Proposed Residential Development - Bradley Villa Farm – Transport Assessment and Travel Plan Review

Prepared for:	Paula Bedford (Highways England)
Prepared by:	Cat Campbell (JSJV)
Date:	23 rd June 2021
Case Reference:	DevWY0043
Document Reference:	TM001
Reviewed/approved by:	Jonathan Parsons (JSJV)

This Technical Memorandum [TM] was prepared by Jacobs Systra Joint Venture [JSJV] on behalf of Highways England and provides a response to the Transport Assessment [TA] and Travel Plan [TP] submitted by Optima, on behalf of Redrow Homes (Yorkshire) Ltd, R Kershaw and S Gill, planning reference 2021/92086.

Image 3.1 M62 Junction 25 (Lower Level Roundabout) – Existing Layout

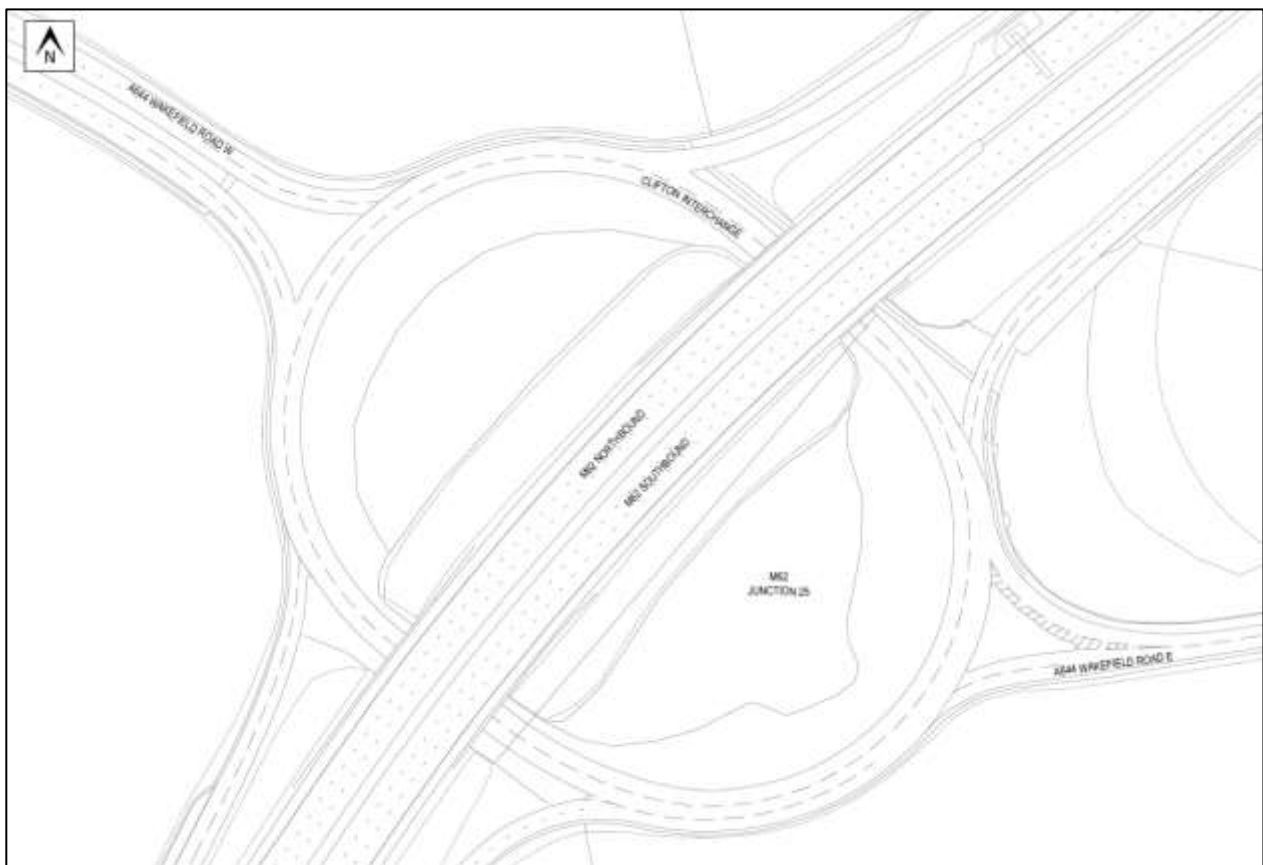
This assessment within the TA identifies that M62 Junction 25 should be modelled, however, M62 Junction 25 has not been modelled within Section 7 of the TA which considers the Phase 1 development proposals.

Initially, it is not clear as to whether the improvements allied to the Clifton Business Park proposals at this location have been included within the junction modelling, and as such, clarification is required on this issue. Furthermore, clarification is required as to whether the assessment of M62 Junction 25 includes the construction and operation of the improvement scheme at Cooper Bridge, which has implications for the operation of M62 Junction 25.

The modelling of the junction presented in the TA shows minimal queuing in the 2018 and 2034 base scenarios, which is not considered by JSJV of how the junction operates at present, and does not reflect the queuing observed on the M62 southbound off-slip, which is caused by queuing on the A644 from Cooper Bridge.

It is stated that the impact of the proposed full HS11 allocation, in terms of highway capacity and safety, does not trigger the requirement of any mitigation at this junction. However, it was requested that M62 Junction 25 be assessed for the Phase 1 development proposals, and this has not been undertaken by Optima.
